Att. Director  
Strategic Assessment  
Department of Planning  
GPO Box 39  
Sydney NSW

**Re: SENIORS LIVING DEVELOPMENT at THE SCOTTISH HOSPITAL  
2 Cooper St., Paddington MP10\_0016, Part 3A**

DRAWING TITLE  
Cross Section C & D

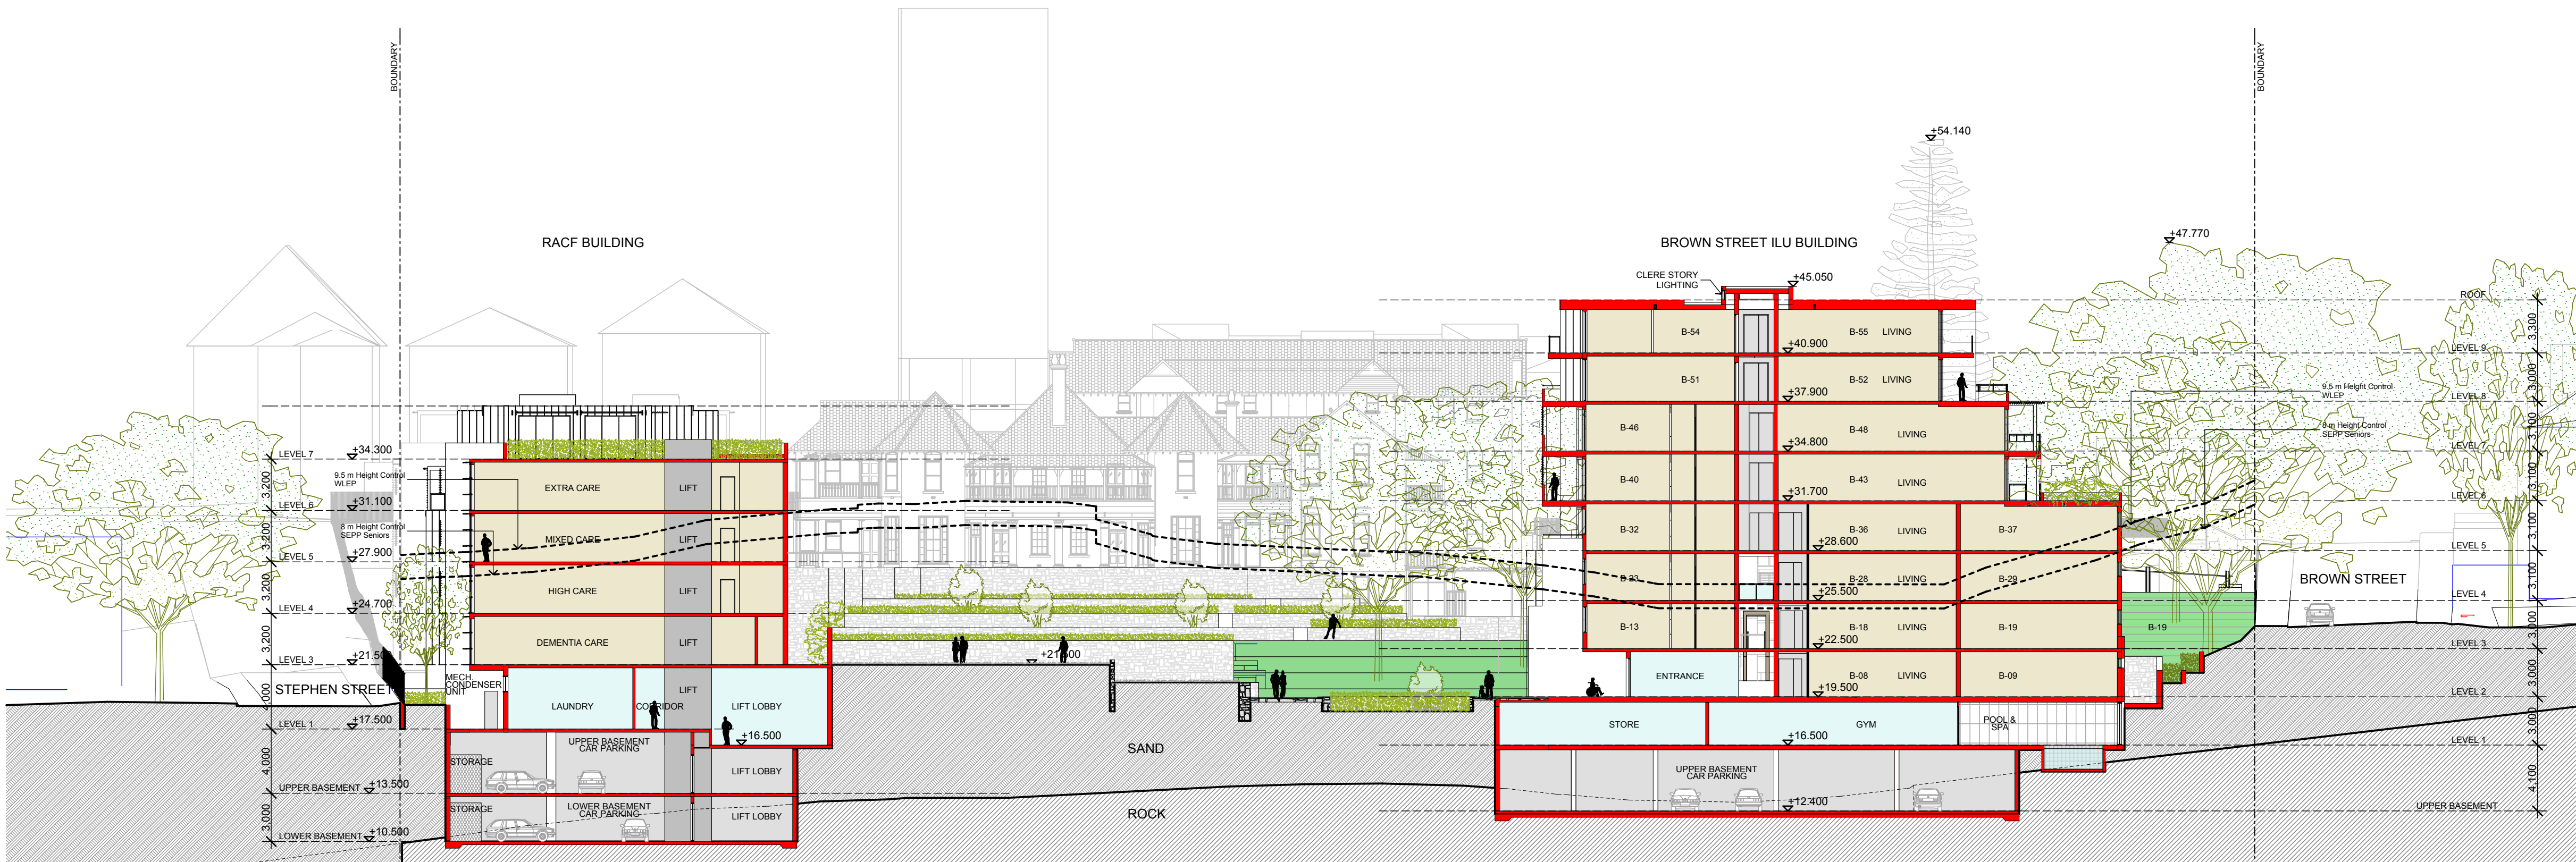
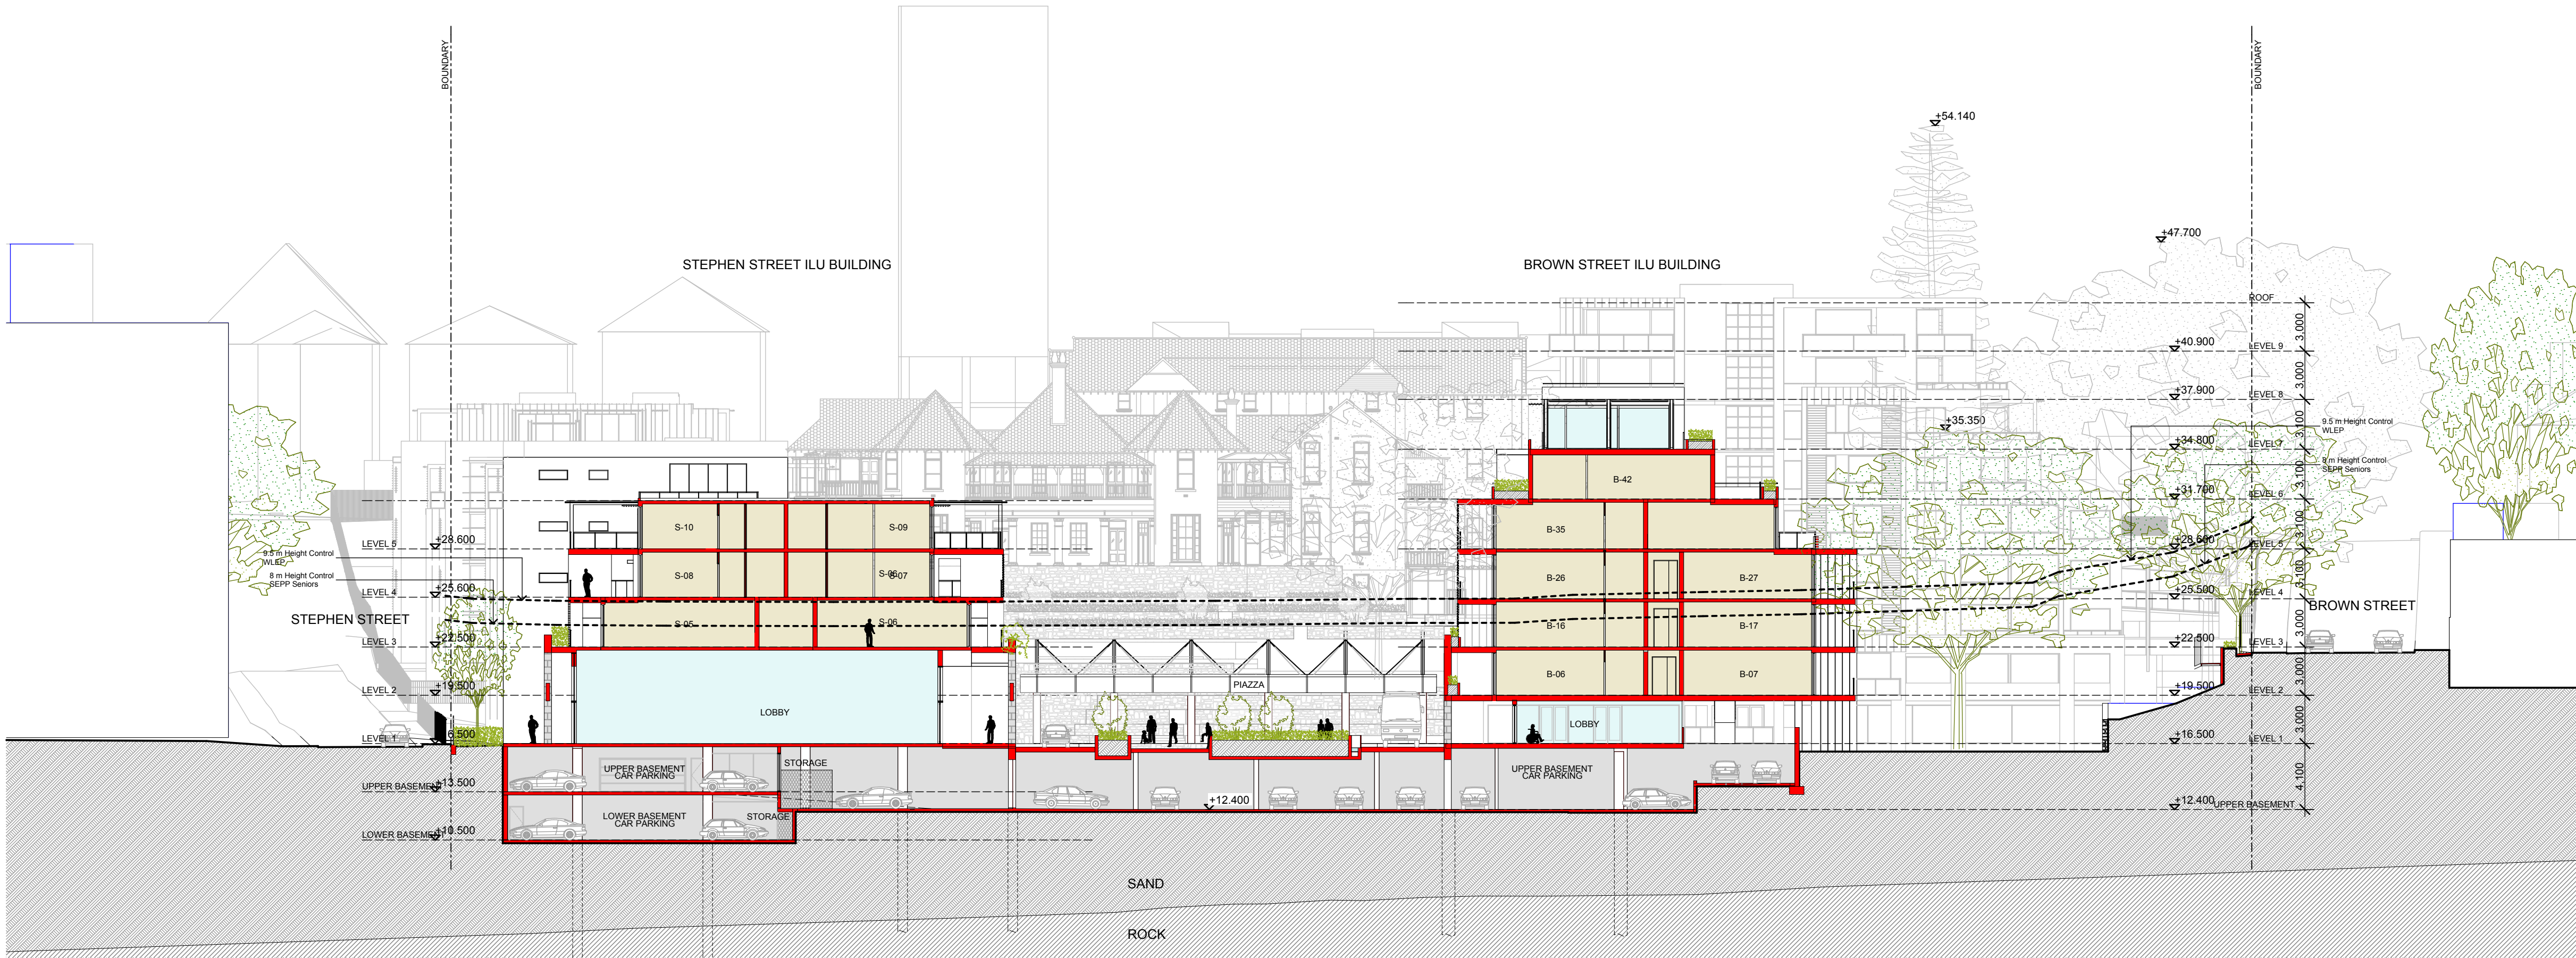
Why do the developers think that they can exceed the 9.5 m LEP height limit at all, let alone by as much as almost 20m in the case of the Brown St. ILU building and over 10m for the RACF building on Stephen St. - a wall of building replaces a wall of trees. Even the so called Gate Keepers lodge exceeds the limit by 3-5m.

Tree protection zones

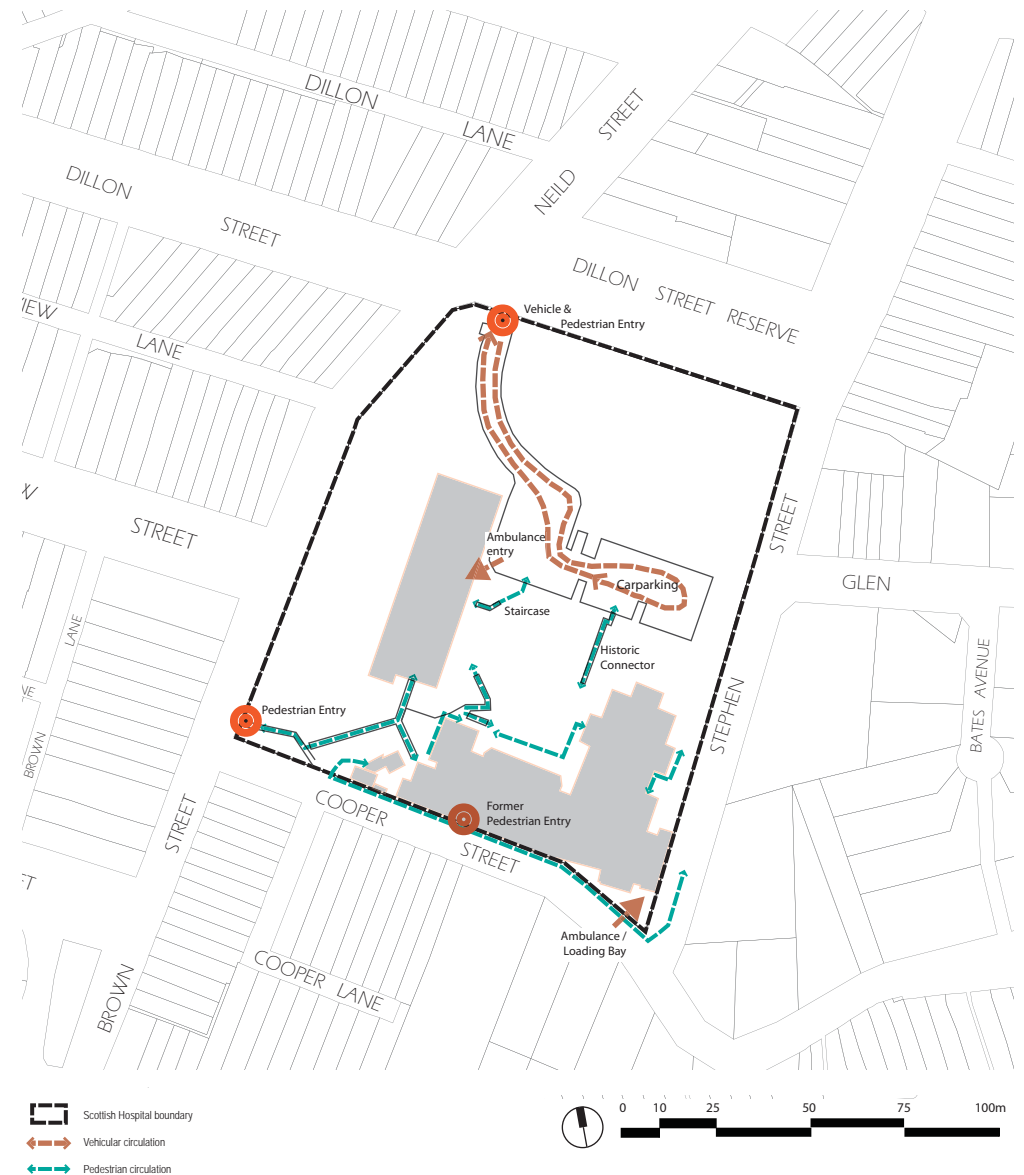
Of the original 9 heritage listed trees, 1 has gone 1 is to be removed and 4 will be under serious threat with buildings sited within their TPZ (Tree Protection Zone) and branches to be pruned to allow for building and /or construction under their canopies.

For example –T18 -the Port Jackson Fig situated on the lower lawn – arguably the most important tree on the site with a TPZ radius of 15m is to have the a basement carpark wall 7.5m from its trunk. Excavation in sand and pile driving will undoubtedly encroach a deal further than this.

The completed building –Stephen St. ILU –at a height of 15m, will encroach 7m into its TPZ and its canopy will require pruning, to accommodate this.

According to the arborist's report, 7 of the retained trees will have piling or shoring within their canopy spread.

Another listed tree, the Kauri pine –T119 to the west of the existing nursing home building, is one of these, showing building within 5m of its trunk. The arborist calls for a TPZ of 15m and a SRZ radius (structural root zone – where earth works should be prohibited) of 5.5.

Similarly, the Norfolk Island Pine- T100, and the Holm Oak- T81, in the south western corner of the site will be under threat with the construction of the "Gatekeepers Lodge" within the TPZ of both these trees.
